Application by RWE Renewables UK Solar and Storage Limited for Tween Bridge Solar Farm Project

The Examining Authority's written questions and requests for information (ExQ2): Issued on 07 July 2026

Scale: 0 0.25 0.5 km

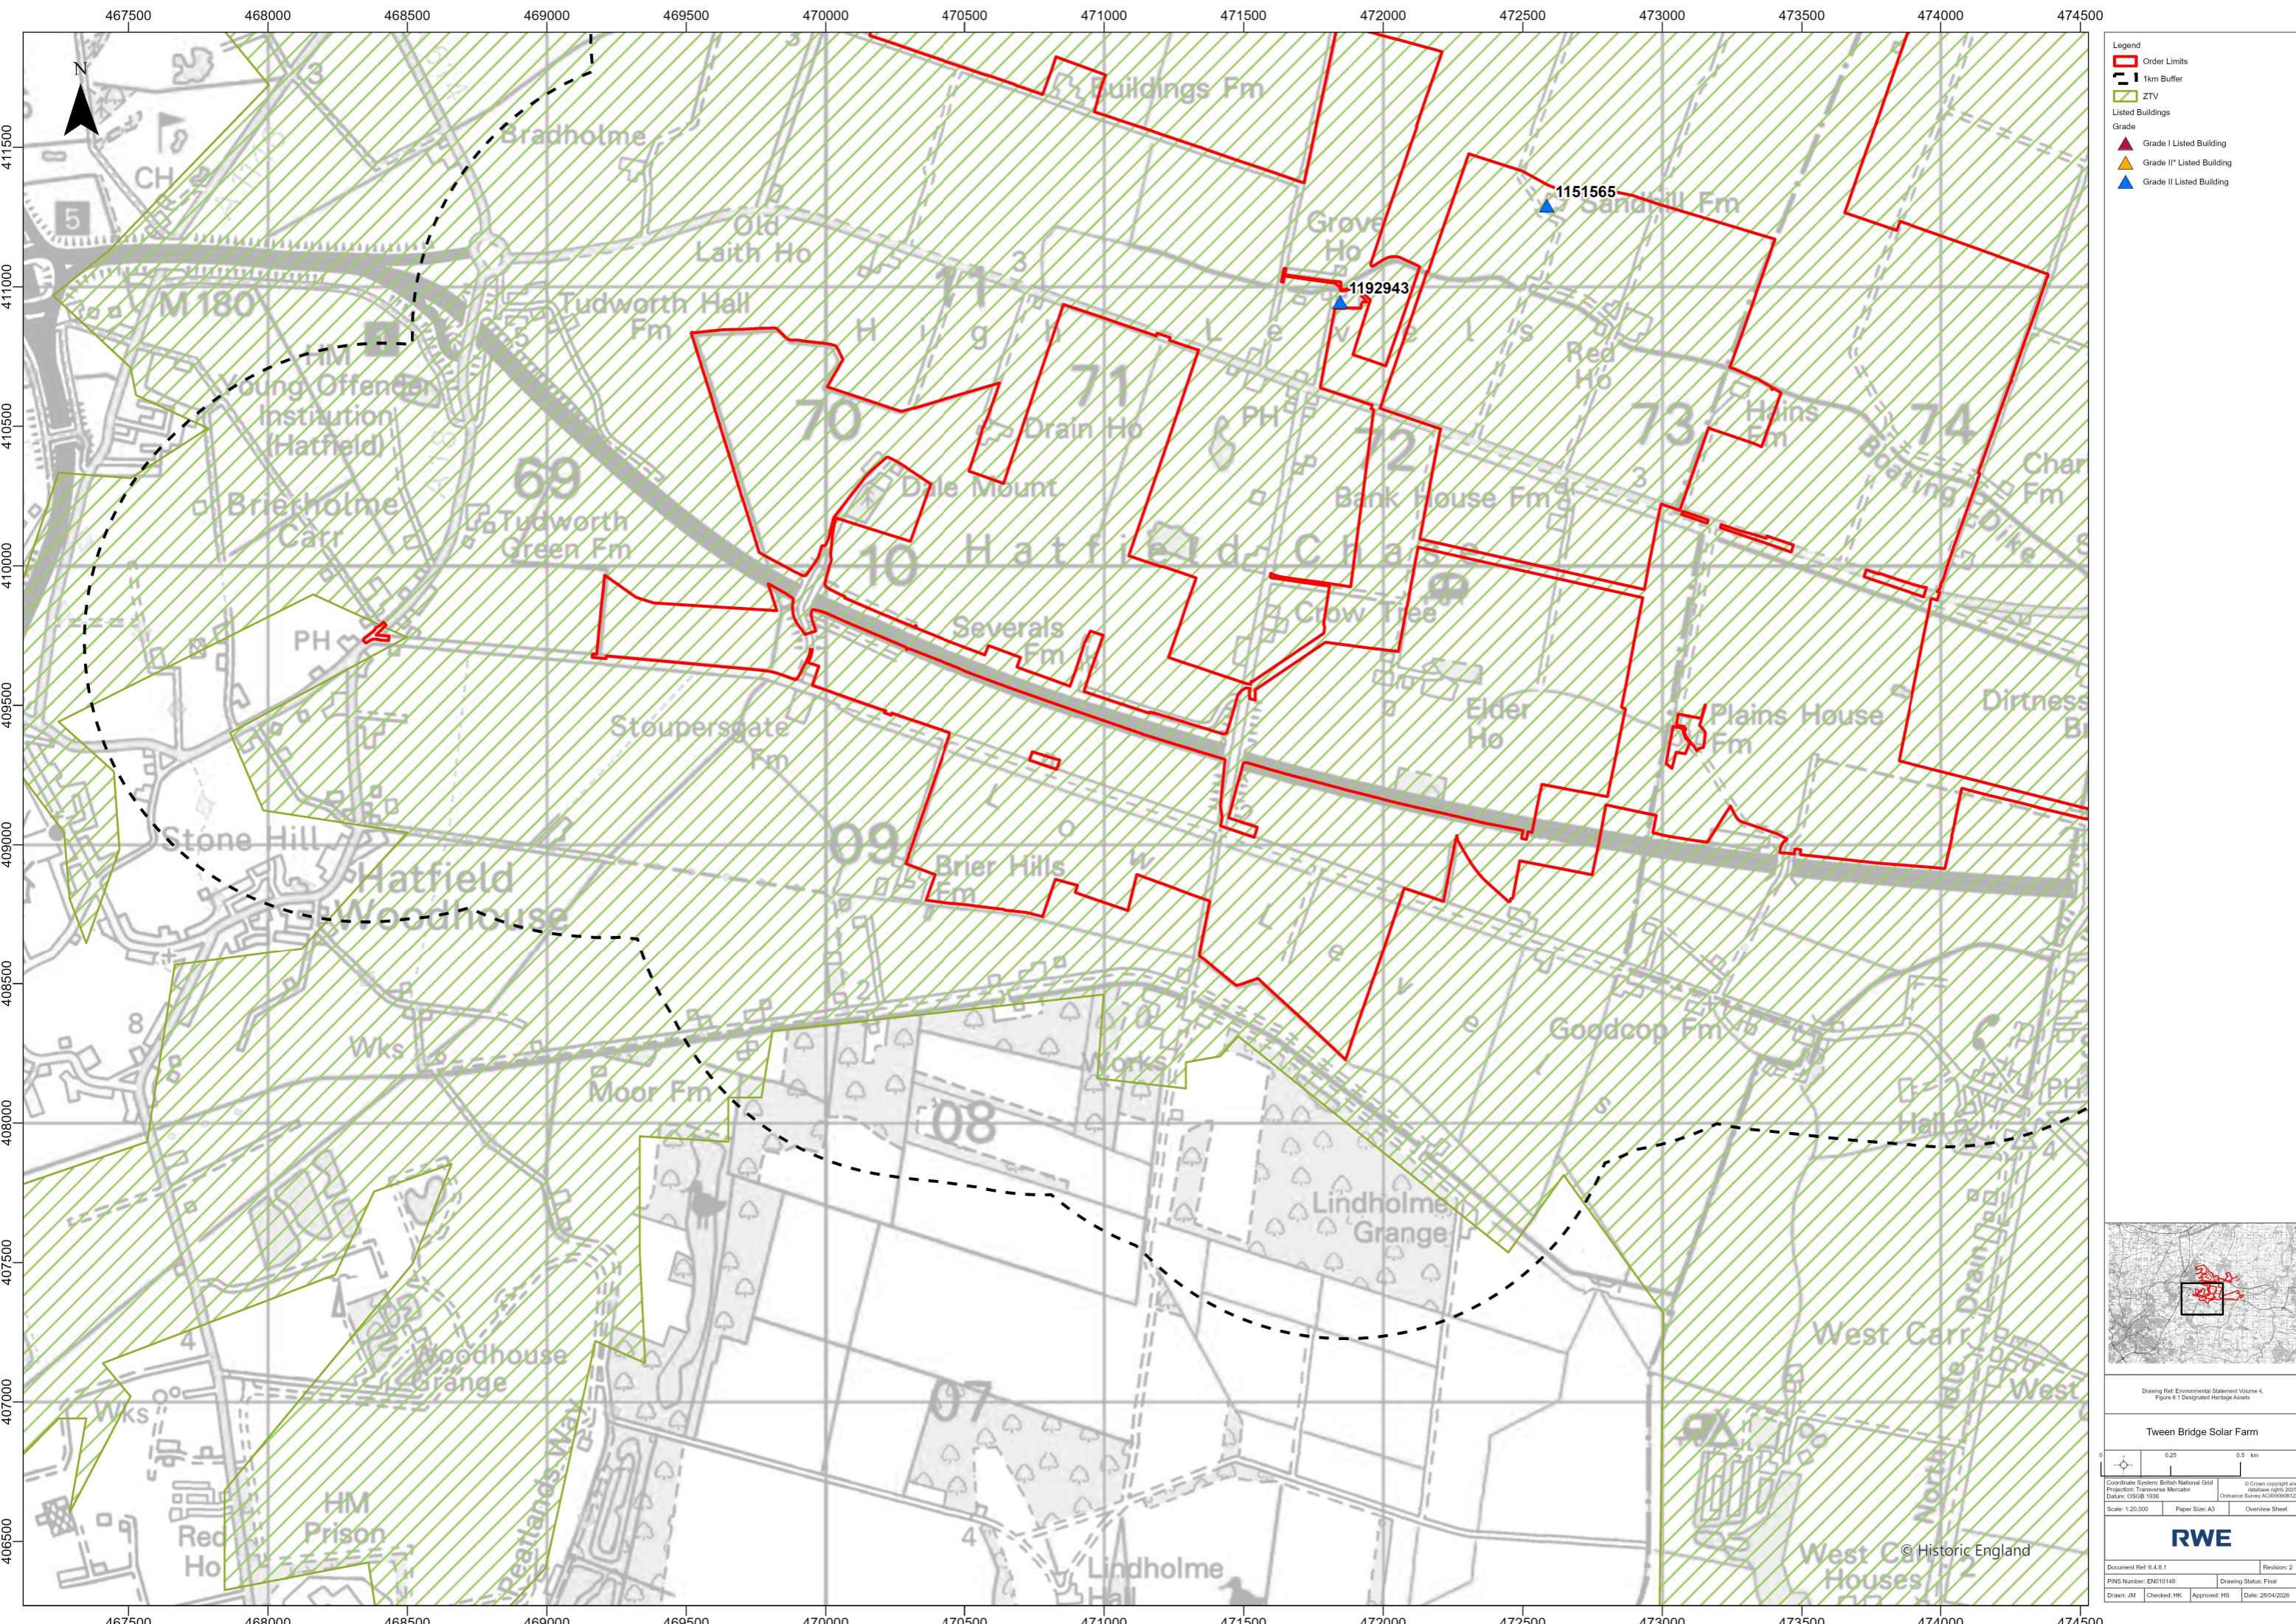
Q2.6.8	Applicant	Heritage assets The applicant's response to EXQ1 6.0.3 [REP2-087] states in part: "The Applicant has revised Figure 1 in ES Appendix 8.1 Heritage Baseline Assessment Document Reference 6.3.8 Revision 2] to show all of the designated heritage assets within the SZTV or 1km buffer around the Order Limits". However, there appear to be some heritage assets located north of Sandtoft and south of the M180 which are within 1km of the order limits. There also appear to be an even larger number which are located within the ZTV (in Sandtoft for example). These are not shown on the figure and should be. They should also be assessed accordingly.
Q2.6.9	Applicant	Q6.0.10 The applicant has provided a response to EXQ1 Q6.0.10 [REP2-087]. However, could the applicant update the ES to include this explanation?
Q2.6.10	Applicant	Archaeology CDC's response to written question 6.0.7 [REP2-099] states in part: "Magnetometry has been relied on as the main evaluation technique but the influence of the alluvial deposits on the effectiveness of the geophysical survey technique has not been resolved. The applicants contend that the survey was targeted at understanding near surface archaeological remains- "Magnetometry was not intended for consideration of deep deposits" (APP-045 ES Ch 8. Table 8-3: Summary of Consultation)- and the geoarchaeological desk-based assessment is the only site wide consideration of the potential for deeply buried remains. In addition, the effectiveness of the geophysical survey in identifying near surface archaeological remains is uncertain. Cropmark data indicated Romano-British activity in the Sandtoft area. Area 3 of the trial trench evaluation targeted this area identifying a Romano-British settlement dated to the 2nd/ 3rd century recording features consistent with the cropmark evidence. Despite only being covered by, on average, 30cm-50cm of topsoil and subsoil, none of the features associated with this settlement were recorded as anomalies by the
